From: [REDACTED]
Sent: 19 October 2017 15:37
To: Michael Eastham
Cc: [REDACTED]
Subject: RE: Amended site layout - the Lillies Caravan park site, Yapton Road, Barnham

From: Sue Howell
Sent: 16 October 2017 10:48
To: Michael Eastham
Subject: RE: Amended site layout - the Lillies Caravan park site, Yapton Road, Barnham

Please could you ask that the developer confirms the total of Open Space (in m²) being provided on this development, as the revised layout does not appear to off any particular gain.

scheme: The Lillies, Yapton Rd
Barnham
client: Matthew Homes
drawing: Landscape Proposals
date: April 2017
scale: 1:200@A1
drawing no: MAT21212 11A sheet 2
drawn: AE checked: DKM

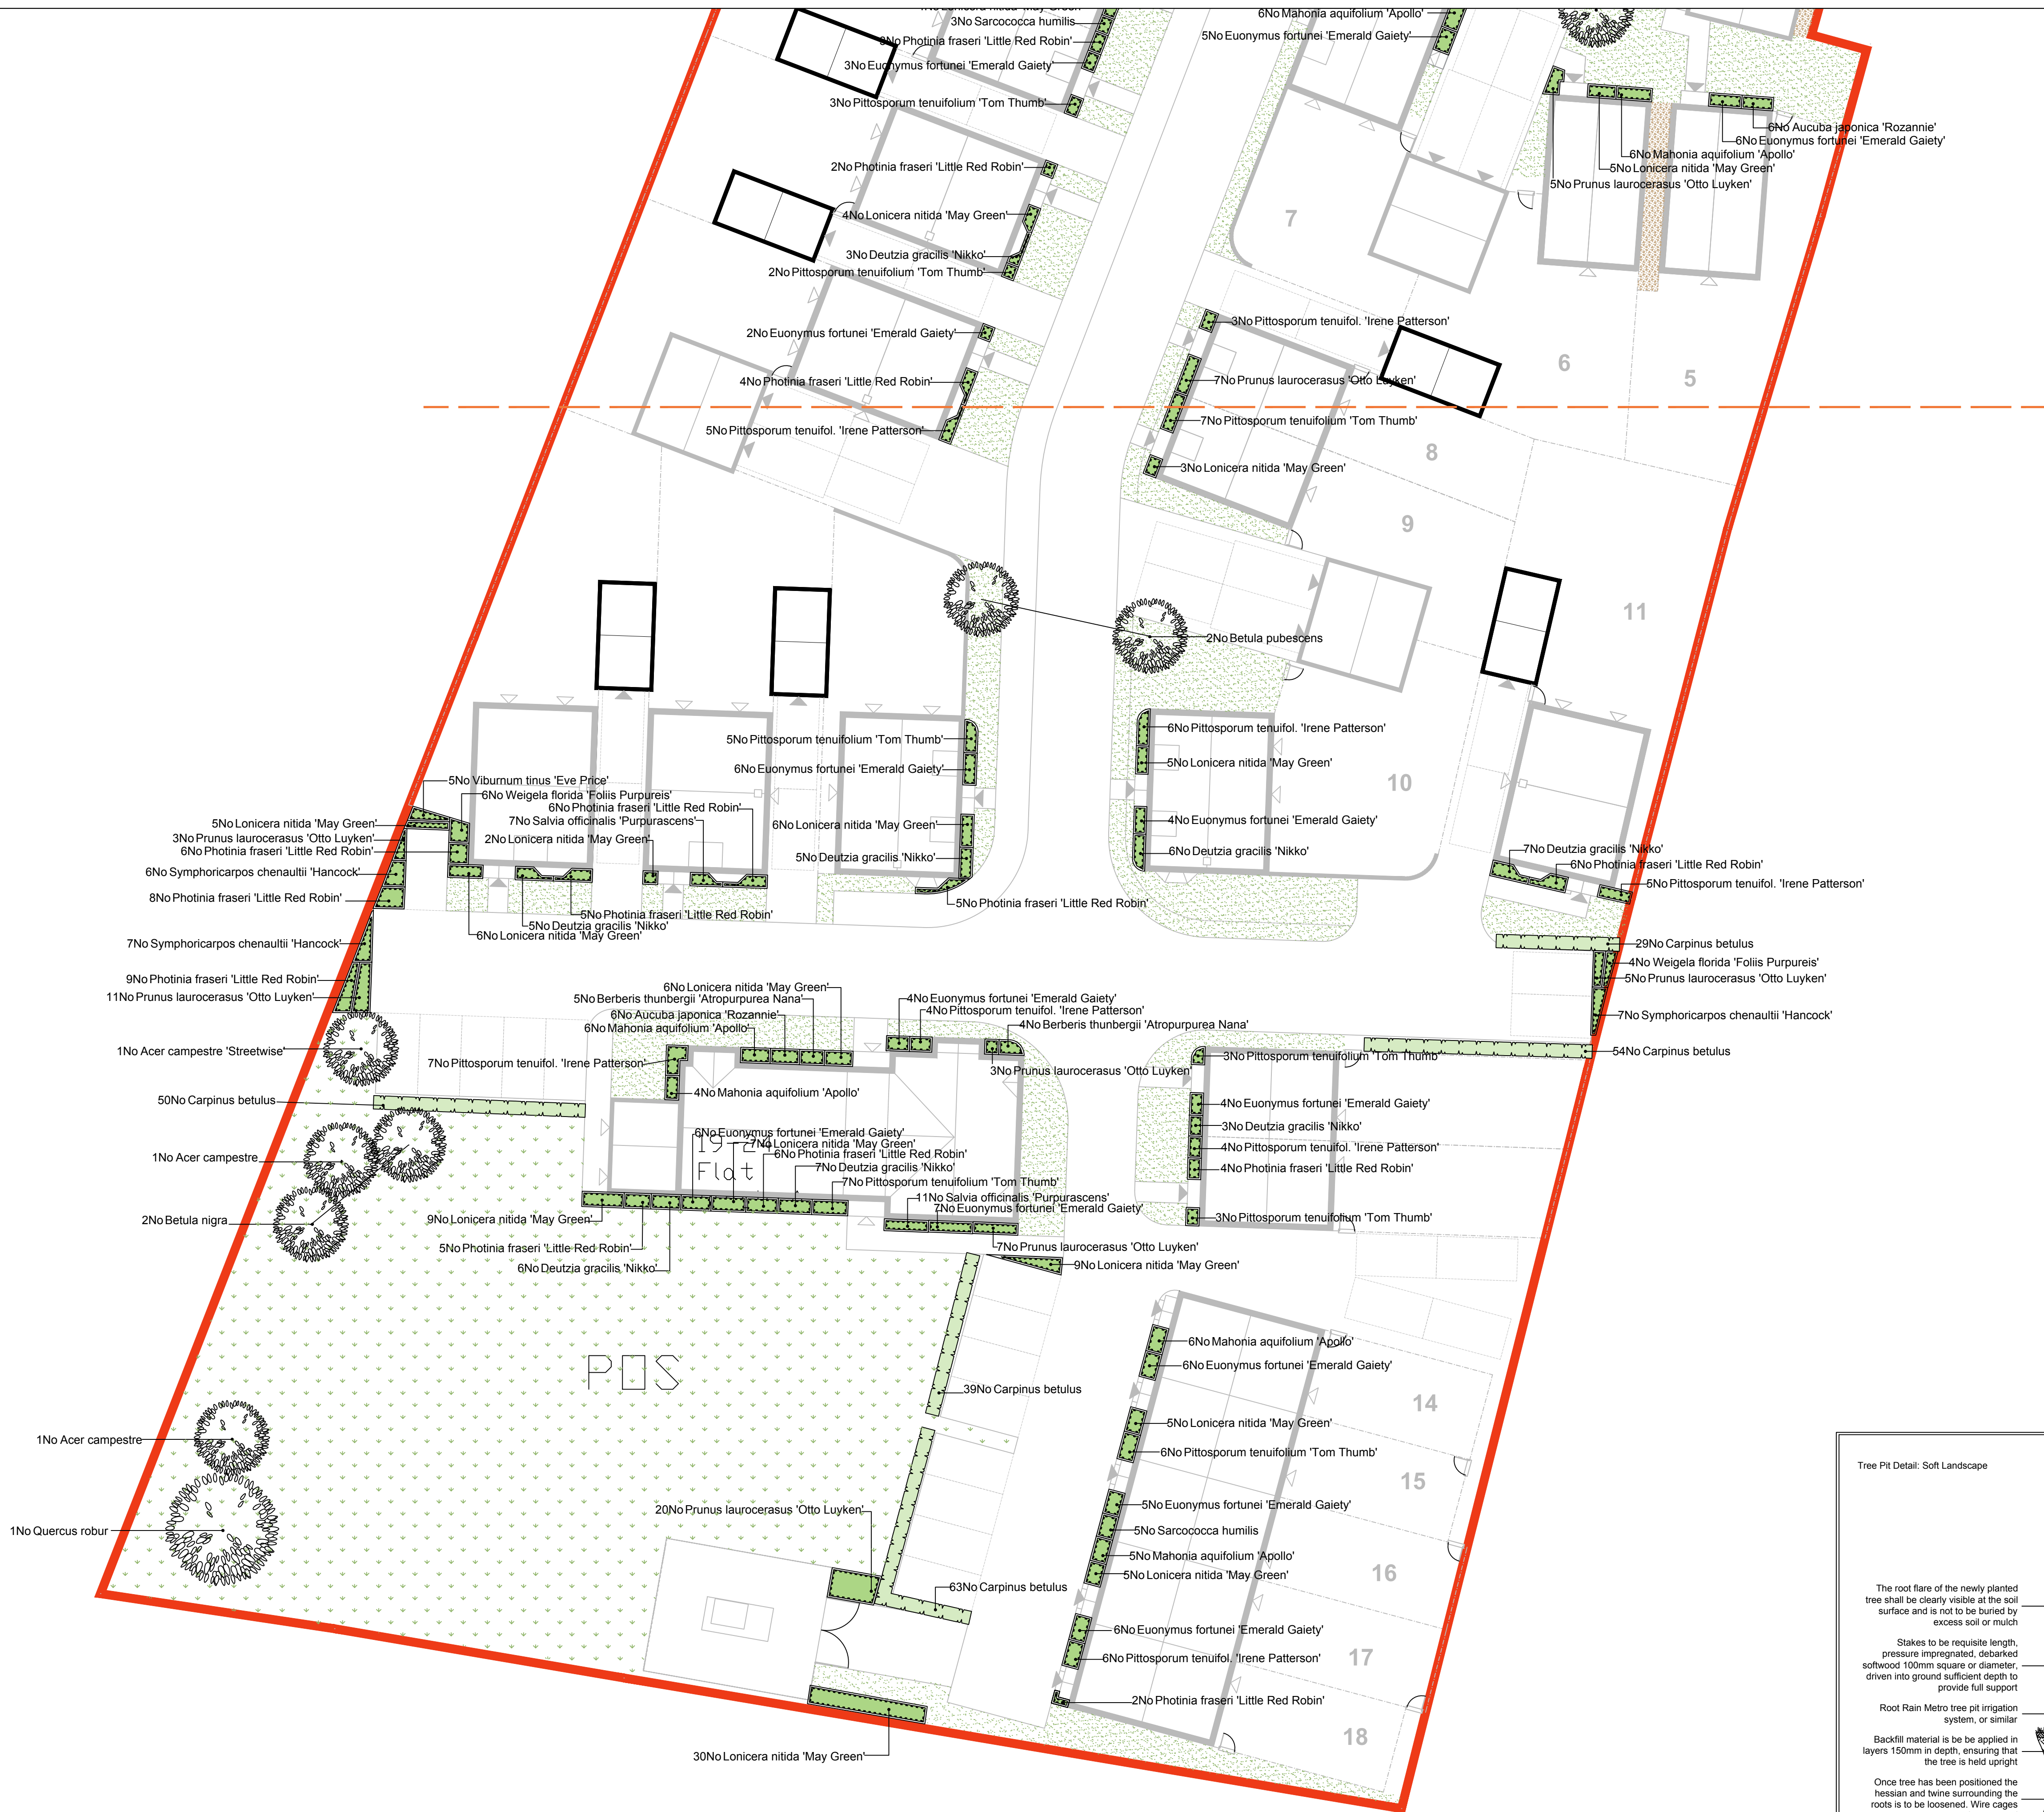
The now indicated attenuation basin to the centre of the POS is also of concern and would require clarification of whether this will be a standing water body? And what element of the year this will be the

case? This area only depletes the POS as it would then not be classed as usable POS? and my concern also is regarding proximity of this in relation to Flat Block A 19-24 which should be raised and addressed.

The basin is not permanently wet and would only have water in if there was a very heavy rainfall thus this area would then be feasible use as POS.

To clarify POS areas the outline allowed for 1344m² approx (scaled from outline drawing) whilst the RMA allows for 1504m² – this is an increase of 160m², another benefit of our scheme over the disjointed outline application.

The flat block is deemed ok location wise to the basin, no issues from the ADC Drainage consultant.
